Our Ref: FP215  
Your Ref: SSD-10344  
SSD-10343

### **STATE SIGNIFICANT DEVELOPMENT APPLICATIONS – BELLA VISTA AND KELLYVILLE**

Thank you for the opportunity to provide feedback on the State Significant Development Applications (SSDAs) for Government-owned land within the Bella Vista and Kellyville Precincts. The following comments are provided on behalf of Council:

Figure 4: EIS Ground Floor Setbacks (left) and as amended by the RtS (right)

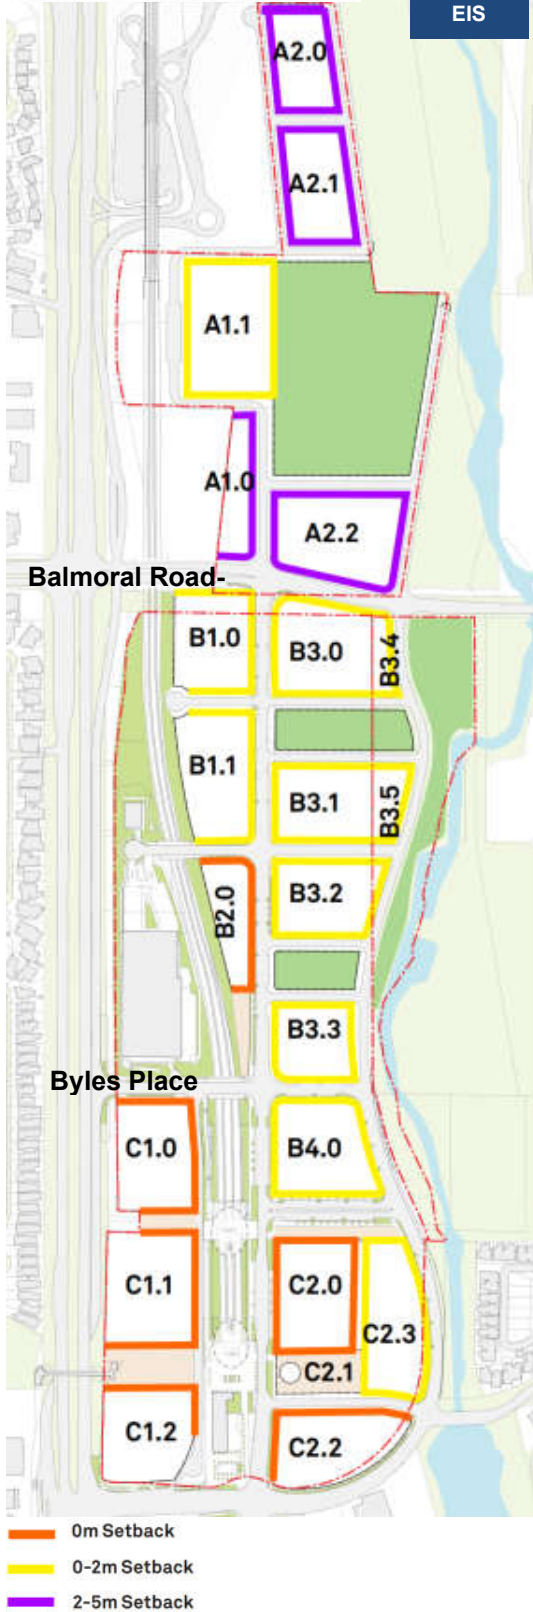
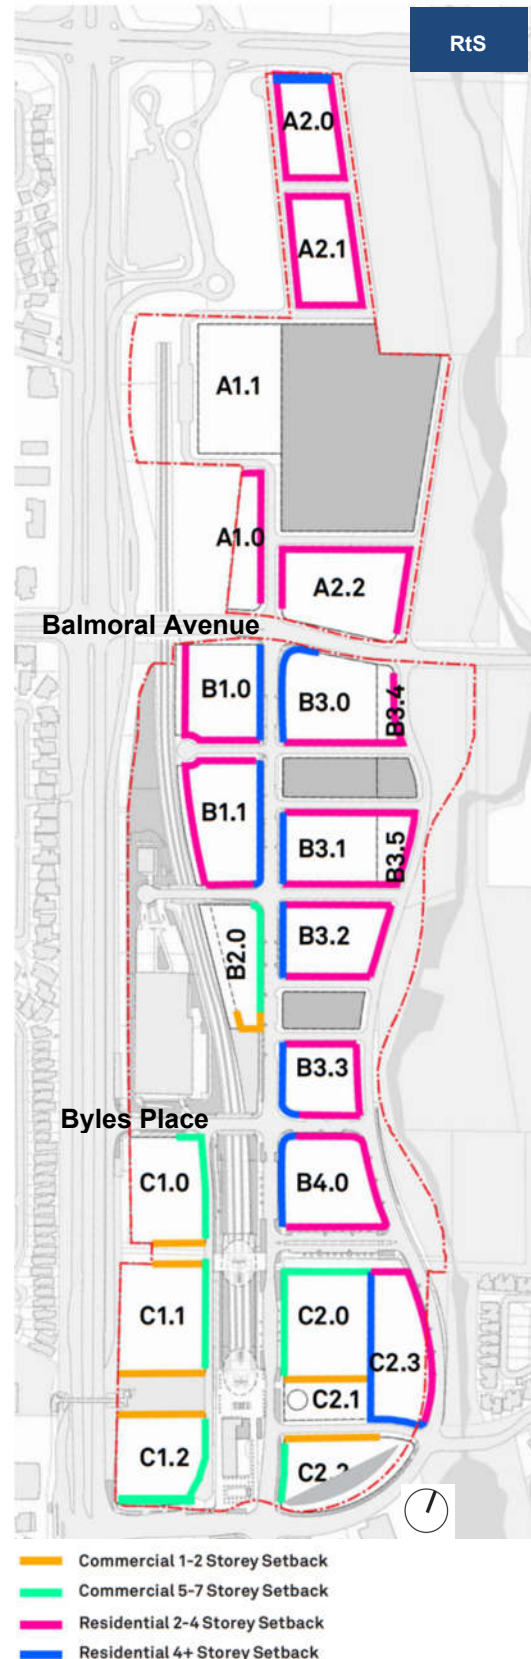
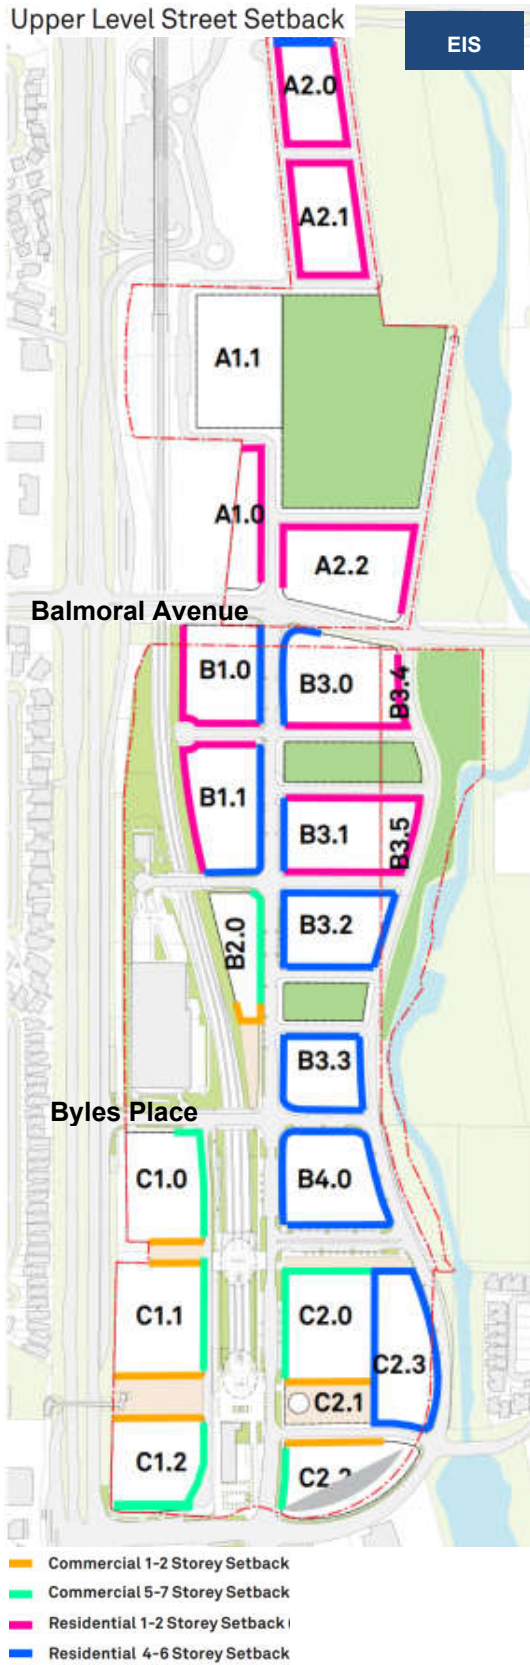
Landcom is seeking to vary the minimum setback controls for residential flat buildings under The Hills LEP 2012 from 5 metres to the following:

*Town Centre / Main Streets*

- Podium: 0-2m
- Upper storeys: further 3m

*Residential Areas / Local Streets*

- Podium: 2-5m
- Upper storeys: further 3m (Kellyville) or 5m from the boundary (Bella Vista)

Landcom's justification is not considered reasonable. The minimum setbacks within The Hills LEP 2012 were set as a result of detailed precinct planning completed by the NSW Government and already vary substantially from Council's typical front setback requirements for apartment buildings of 10 metres. The reduced setback within the LEP already acknowledges the urban character of these areas, whilst continuing to allow reasonable space for deep soil planting and larger tree species, providing a green and leafy character, increased urban tree canopy and increased privacy for future residents. Greater setbacks would also enhance solar access to streets and reduce wind impacts which are highly desirable from an amenity perspective in high density areas.

It is also considered inappropriate to vary the requirements as part of a master plan approval, without any detailed concepts for individual buildings to justify the variation. It is noted that there would remain scope for variation to setbacks to be considered on a case-by-case basis as part of future built form applications for individual buildings. This would allow for consideration of variations having regard to the detailed design of individual buildings and specific opportunities and constraints afforded by individual sites.

An approach could be applied within the Bella Vista and Kellyville Precincts consistent with Council's adopted DCP controls for other station precincts (Showground and Castle Hill North) where a setback of 3 metres can be applied where apartment developments proposed a 'terrace edge'.

Figure 10: EIS Building Envelopes in Residential Core and Local Hub (red outlines)

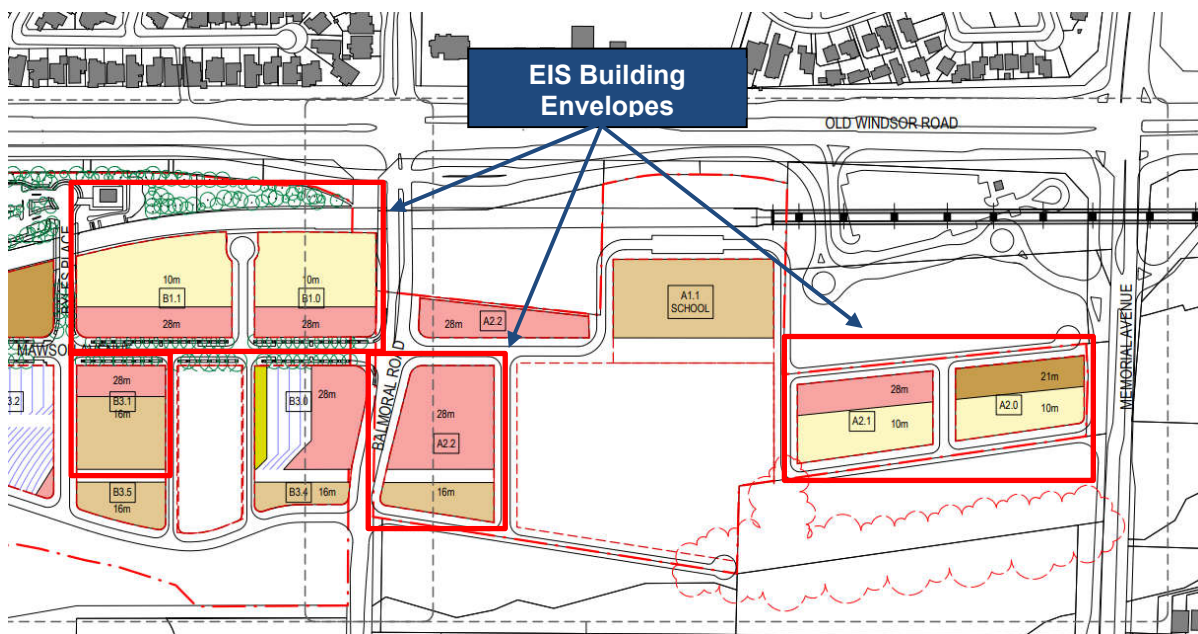
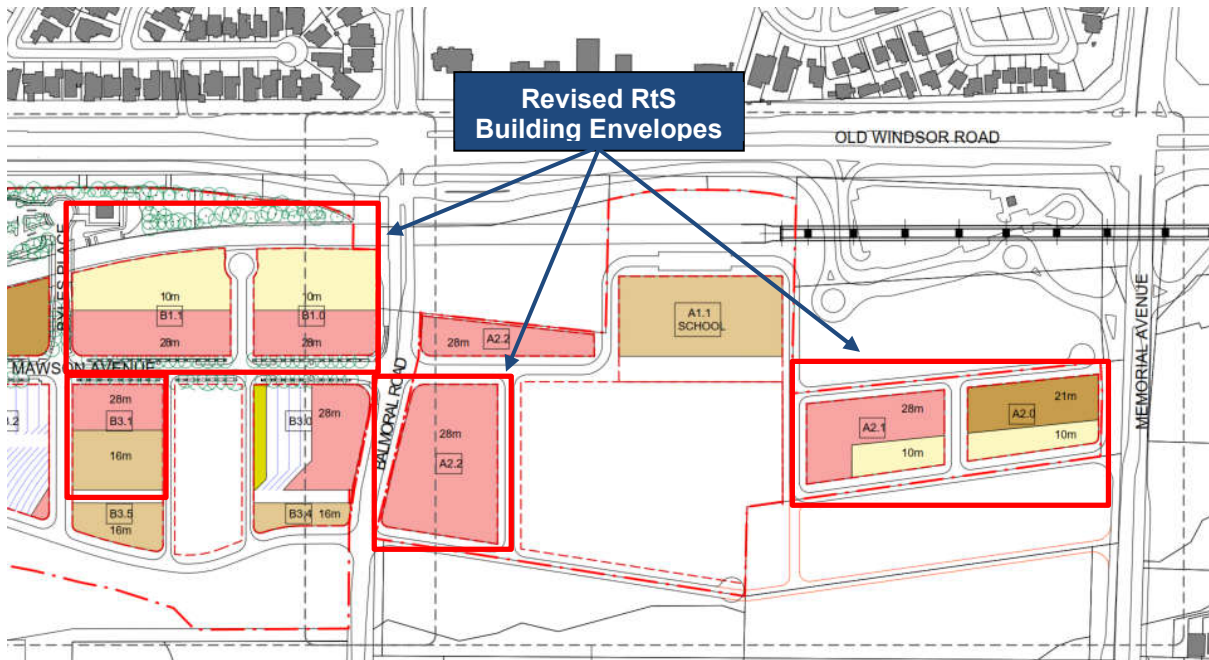
Clarification should be provided of whether the proposed building envelopes are inclusive of plant and lift overruns. These features should not protrude about the maximum permissible building height unless fully integrated into the design of an architectural roof feature in accordance with Clause 5.6 of The Hills LEP 2012.

Concern is raised with respect to the visual bulk of buildings which in some cases exceed 65 metres in length. It is recommended that a control be applied within both Precincts which is consistent with the adopted DCP controls for other station precincts (Showground and Castle Hill North) and imposes a maximum building length of 65 metres.

Figure 12: Development Blocks Identified for Terrace Typologies

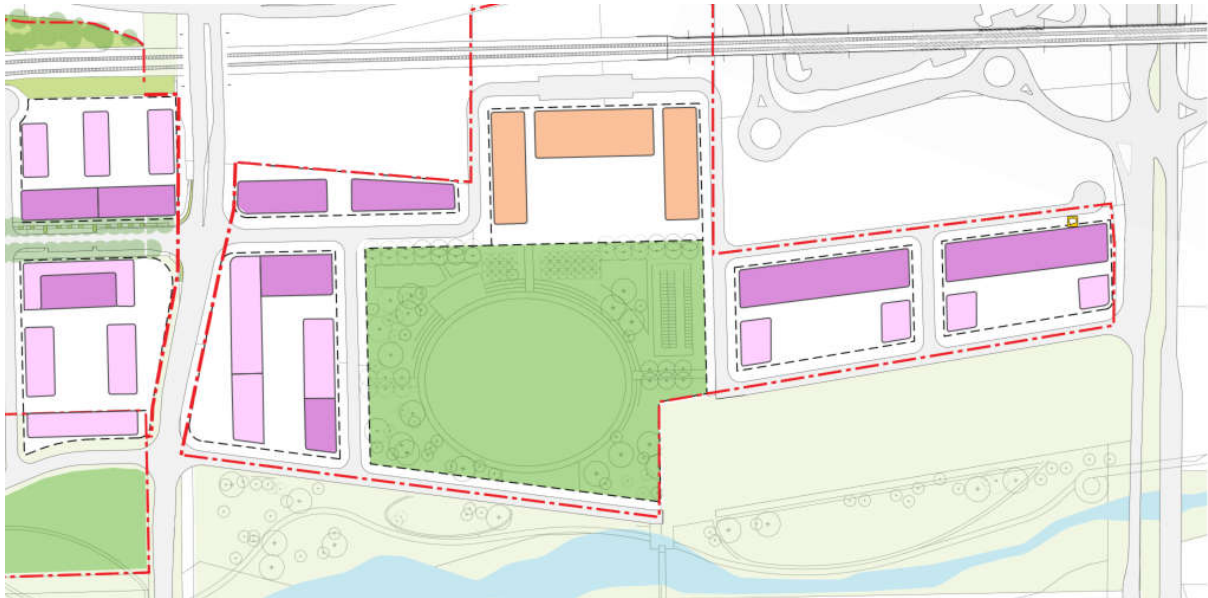
The proposed mix of medium and higher density housing is considered a positive outcome. Whilst the proposed GFA ranges will go some way to securing the provision of medium density forms such as terraces, it is considered this could be further secured by specifying a minimum percentage of terrace style housing for certain sites.

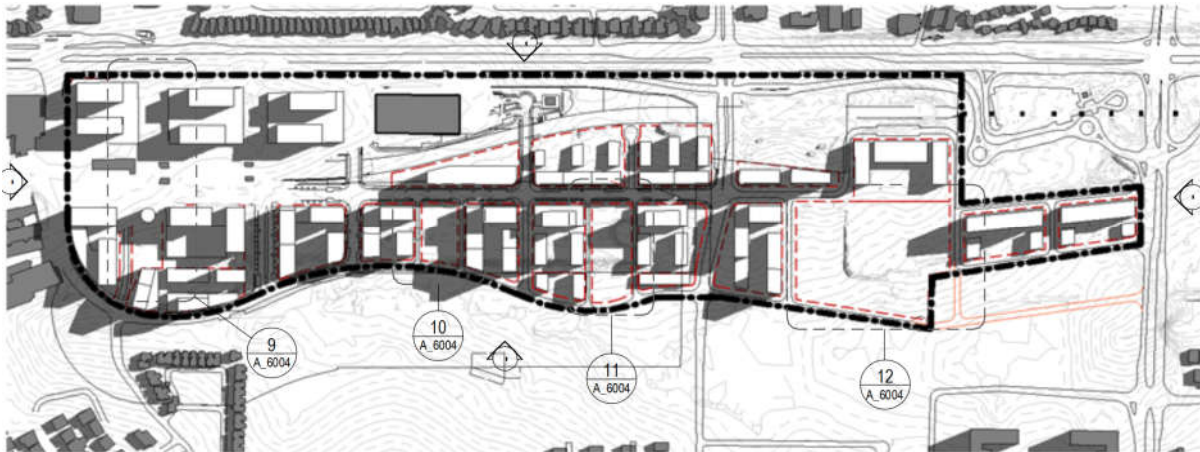
No detailed overshadowing analysis has been provided for the Bella Vista Precinct. This should be submitted for review.

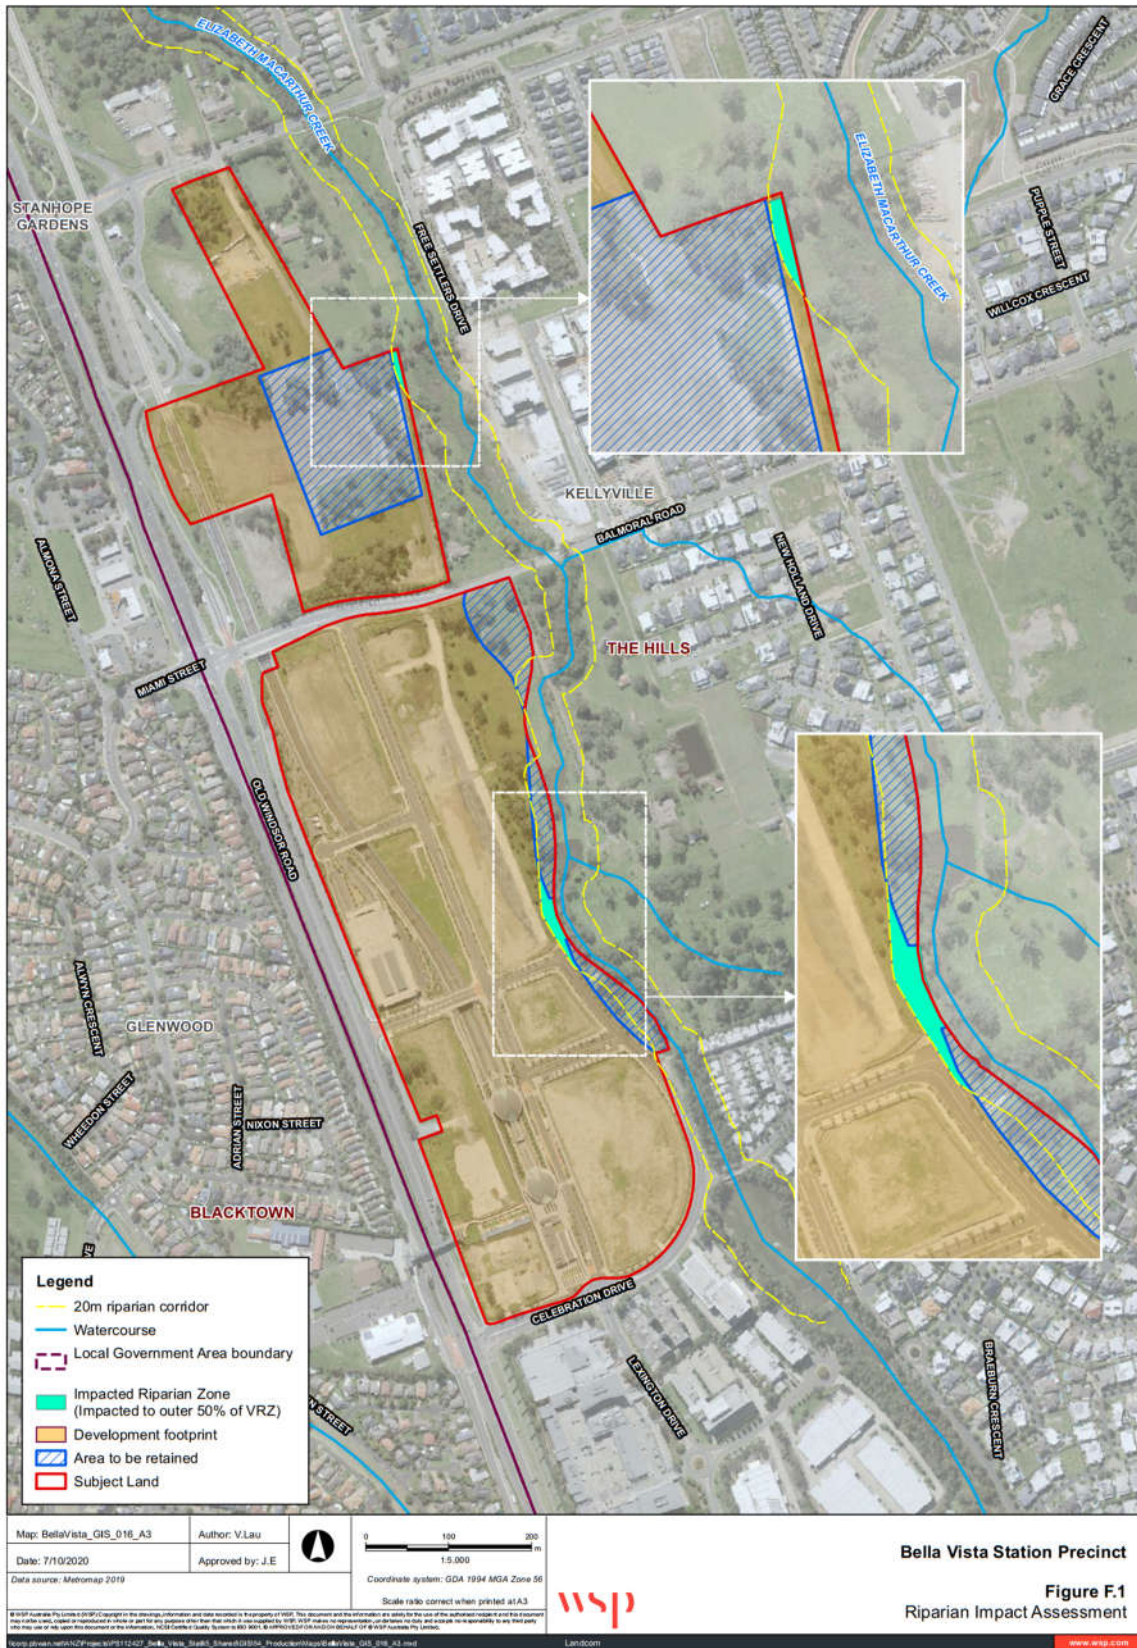
A riparian assessment for the Bella Vista precinct should be submitted, similar to that provided for Kellyville. Further progression of the Kellyville precinct SSDA and future Development Applications ought to comply with mitigation measures specified in the riparian assessment completed by EcoLogical Australia in support of the Kellyville precinct SSDA.
